Our ref: HA/2017/119232/01-L01
Your ref: FP/21/17/PL
Date: 03 April 2017

1 NO. DWELLING WITH DETACHED GARAGE TO FRONT.

31 RIFE WAY, FELPHAM, PO22 7BN.

Proposals Plan - Scale 1:500

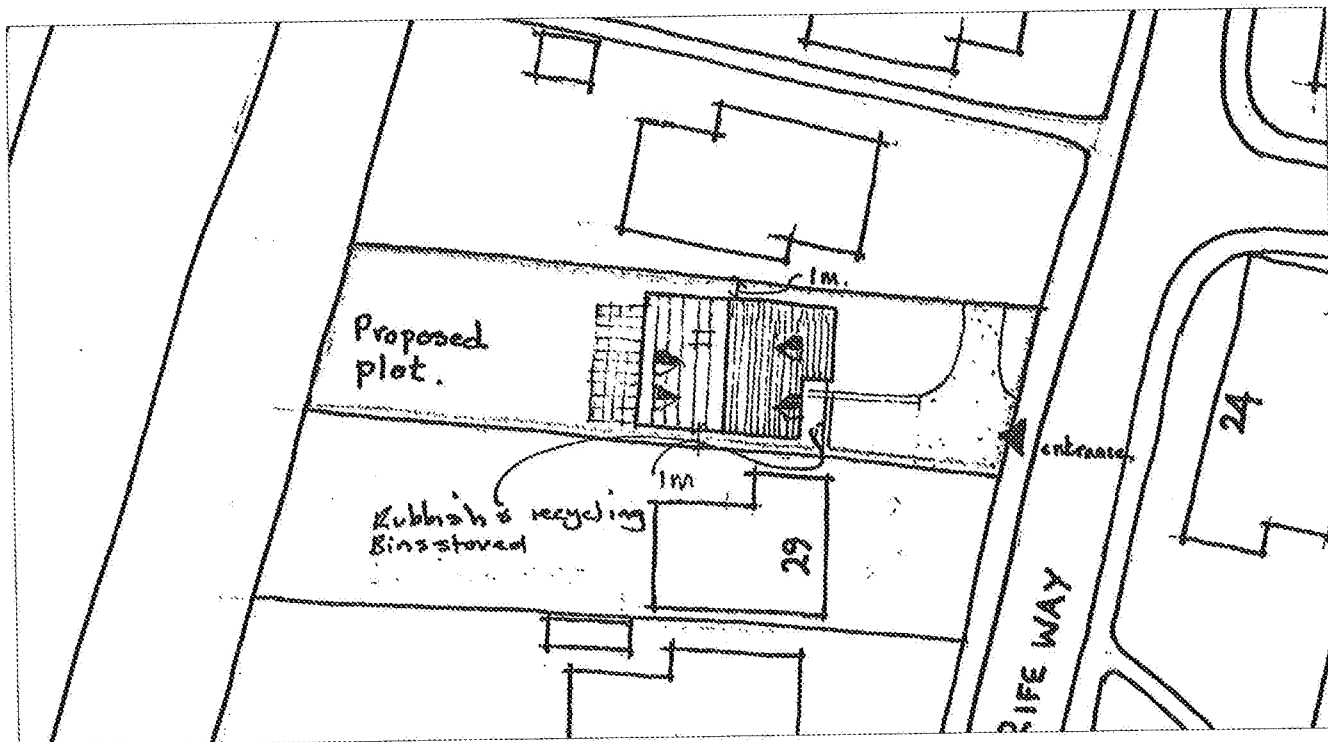
According to the Environment Agency maps and records the site is shown to be within a Flood Zone 3 (high risk) tidal and fluvial flood risk area.

On the basis that historically the site was occupied by a previous dwelling, and the new dwelling will result in a betterment, based on the resubmitted Flood Risk Assessment (FRA) we recommend that the following condition of planning be imposed.

The development permitted by this planning permission shall only be carried out in accordance with the approved Flood Risk Assessment (FRA) and the following mitigation measures detailed within the FRA:

1. Finished floor levels are set no lower than 2.3m above Ordnance Datum (AOD).
2. The mitigation measures shall be fully implemented prior to occupation and subsequently in accordance with the timing / phasing arrangements embodied within the scheme, or within any other period as may subsequently be agreed, in writing, by the local planning authority.
